Recommendation Report for Planning Permission for Works or Extension to a Dwelling

REF NO: BR/103/18/HH

LOCATION: 40 Hatherleigh Gardens
Bognor Regis
PO21 5HY

PROPOSAL: Rear & side extension

GROUND FLOOR PLAN
[As Proposed]

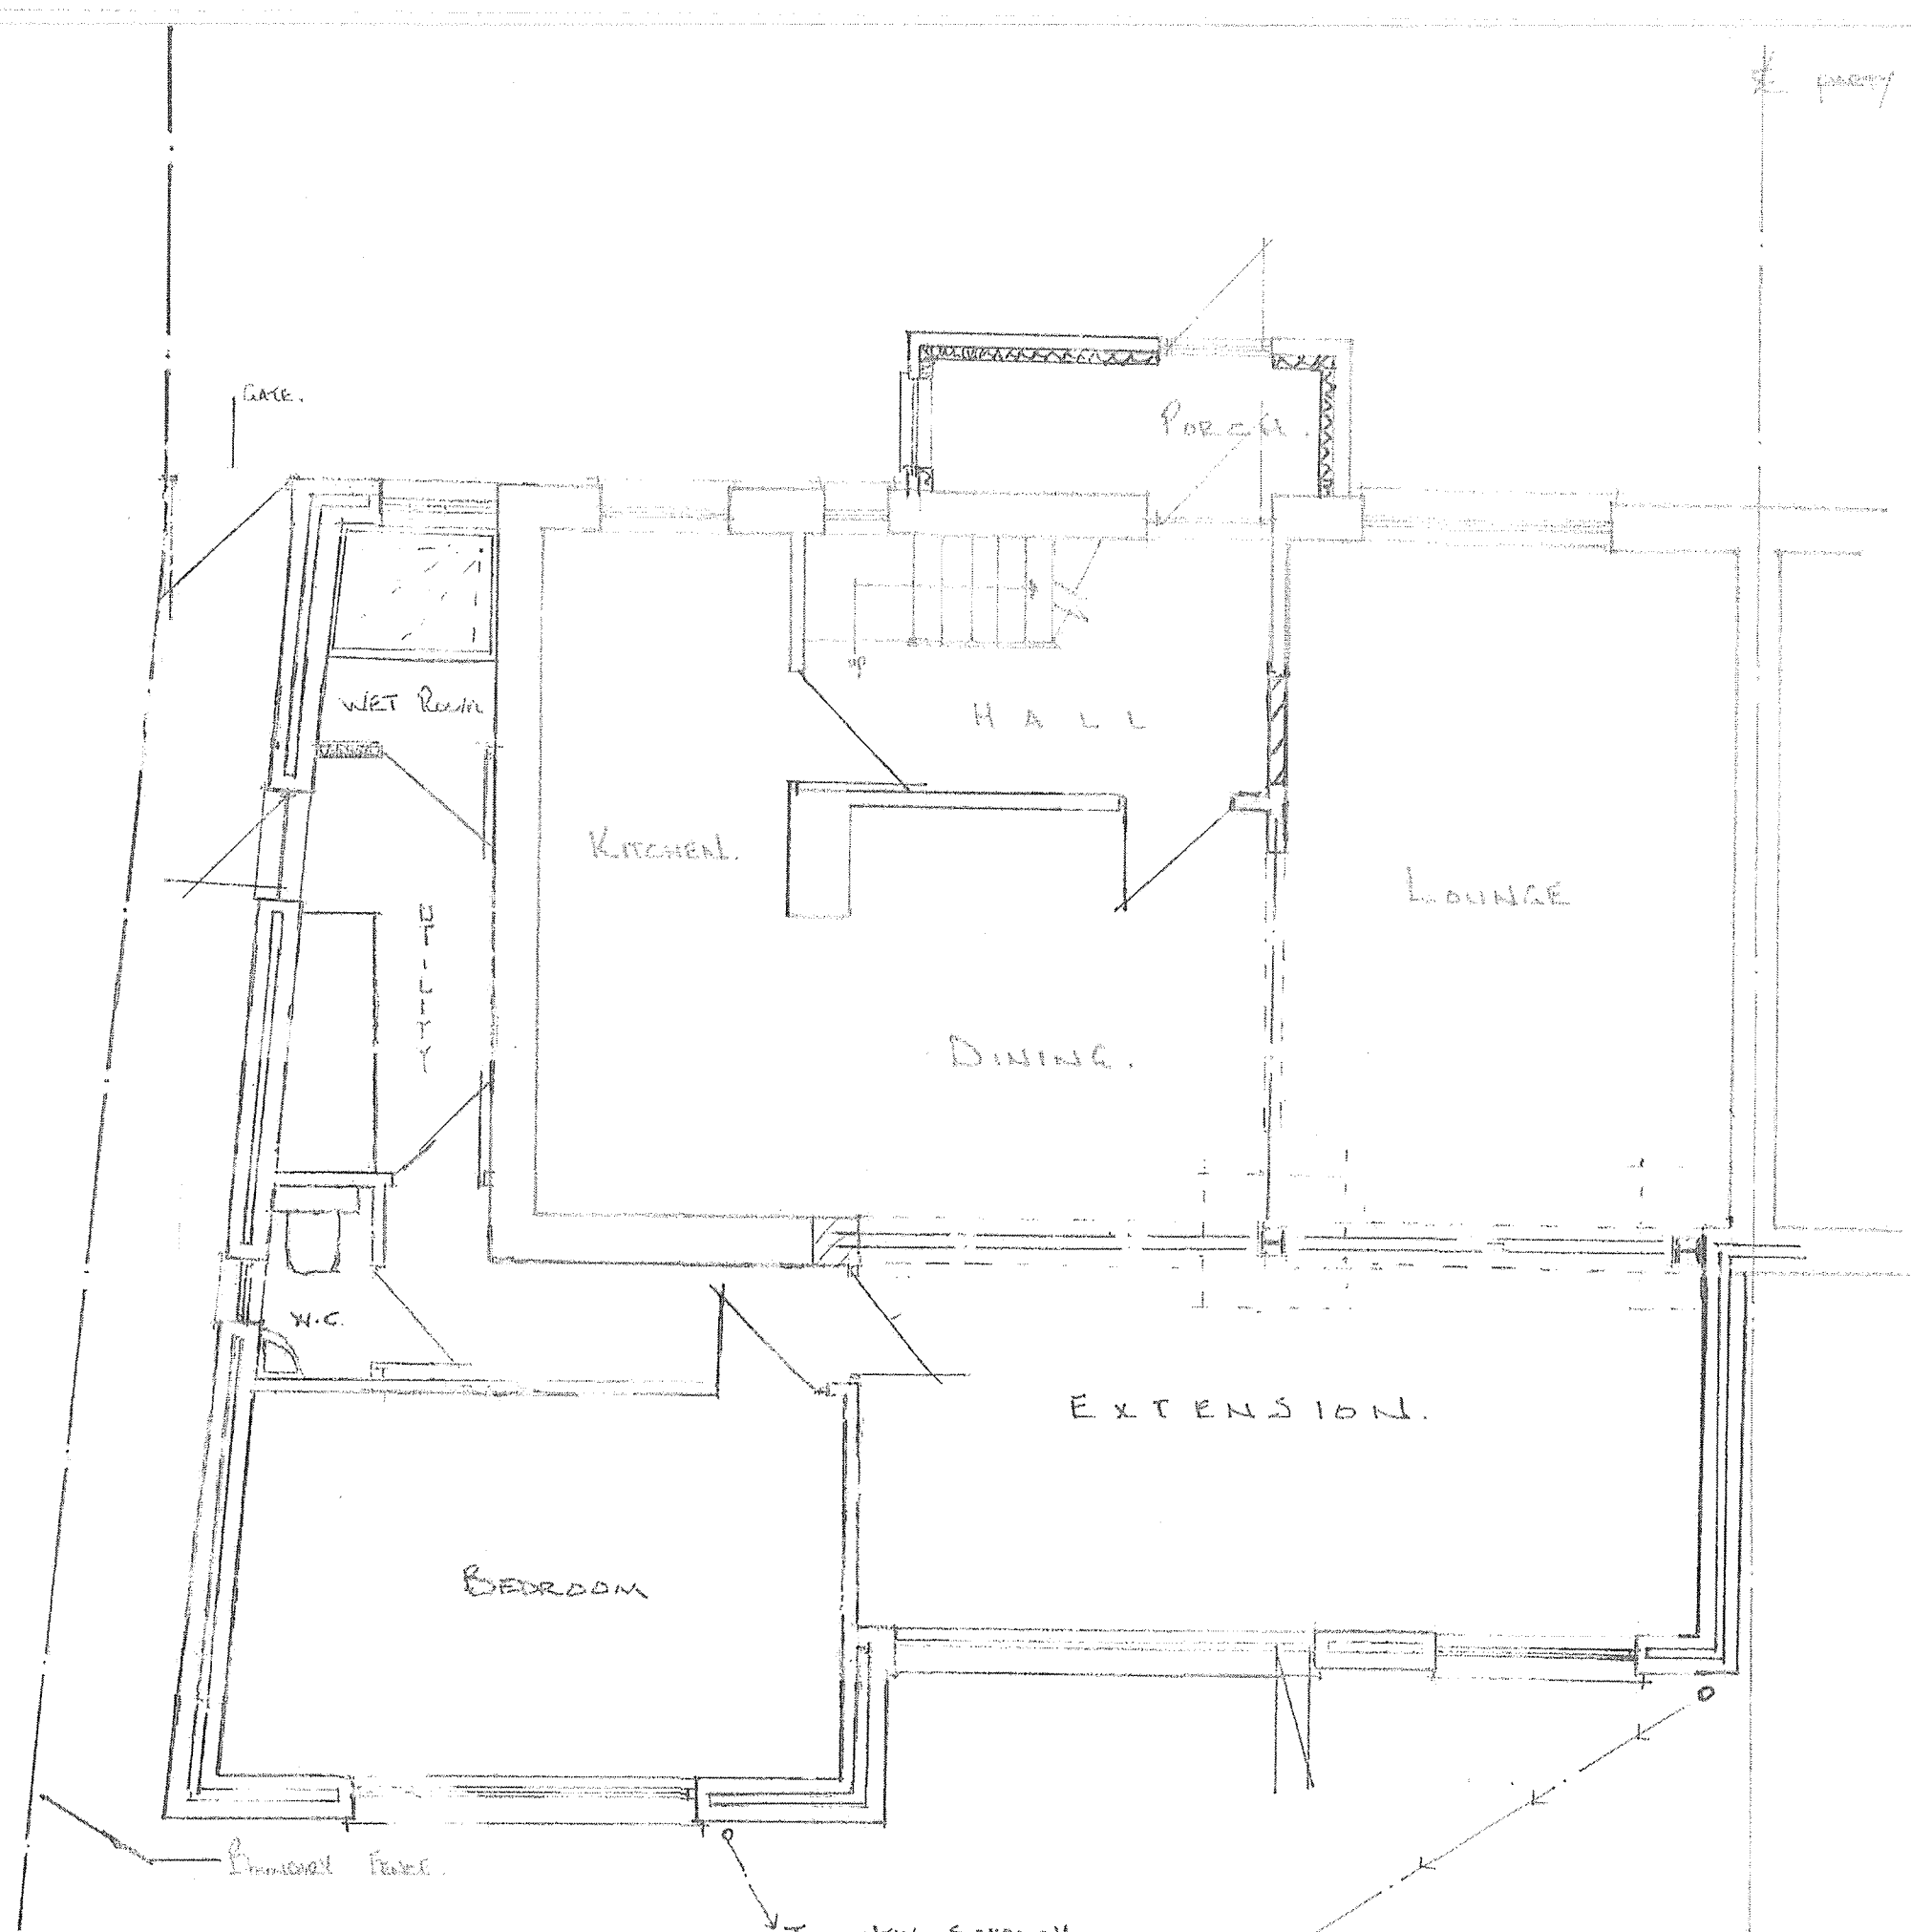
A large proportion of the proposal would be sited to the rear of the dwelling and as such would not be visible from the highway. The main part of the proposal that would be visible from the highway would be the proposed side extension and rear projection. The proposed side extension would taper toward the front of the host dwelling. The side extension would not extend past the front elevation of the host dwelling and would be set in from the common boundary of adjoining property number 38 and the rear of

the highway a sufficient distance, 0.8 of a metre. As such given the separation distance and that the proposed side extension would be single storey it is considered that a terracing effect would not occur.

The proposed extension is a wraparound L-shaped extension, consisting of rear and side elements. Officers note that the side elevation of adjoining property number 38 features a front door and a very small window in the side elevation at ground floor facing the proposal. From an assessment of the proposed side extension and rear projection, it is considered that while it brings the built form closer to that of adjoining property number 38, it would be set in from the common boundary by approximately 0.8 of a metre. Additionally it is noted that the proposal would project past the single storey rear extension at adjoining property number 38. There is a window in the rear elevation of the aforementioned extension at number 38 and while Officers do not know what room the window serves, it is considered that no detrimental impact would occur with regard to loss of light.

The proposal would be single storey, set in from the common boundary and a 2.0 metre high close boarded fence could be erected along the common boundary. Therefore, it is considered that the proposed side extension and rear projecting element would not have a detrimental impact upon the residential amenity of the occupiers at adjoining property number 38, with regard to overlooking, overshadowing, overbearing effect and loss of light/sunlight.

The proposal also includes a single storey rear extension which would be sited closer to the common boundary of adjoining property number 42, than the existing rear extension. Due to the boundary hedge it is not clear where the ground floor windows in the rear of number 42 are. However, having regard to the boundary hedging, which has an approximate height of 2.0 metres, Officers consider that any windows close to the hedge would already be subject to some loss of light. Additionally having regard to the depth of extensions permitted under Permitted Development the element of the rear extension closest to number 42 would have a depth of 2.3 metres and would comply. Therefore, Officers consider the proposed rear extension to be acceptable with regards to loss of light/sunlight, overbearing effect and overshadowing.

With regard to overlooking from the proposed rear extension it is considered that there is sufficient screening to the common boundary of adjoining property 42. Should the hedge ever be removed or die in the future, any overlooking would be to the rear portion of the rear garden of number 42, rather than the primary amenity space immediately to the rear.
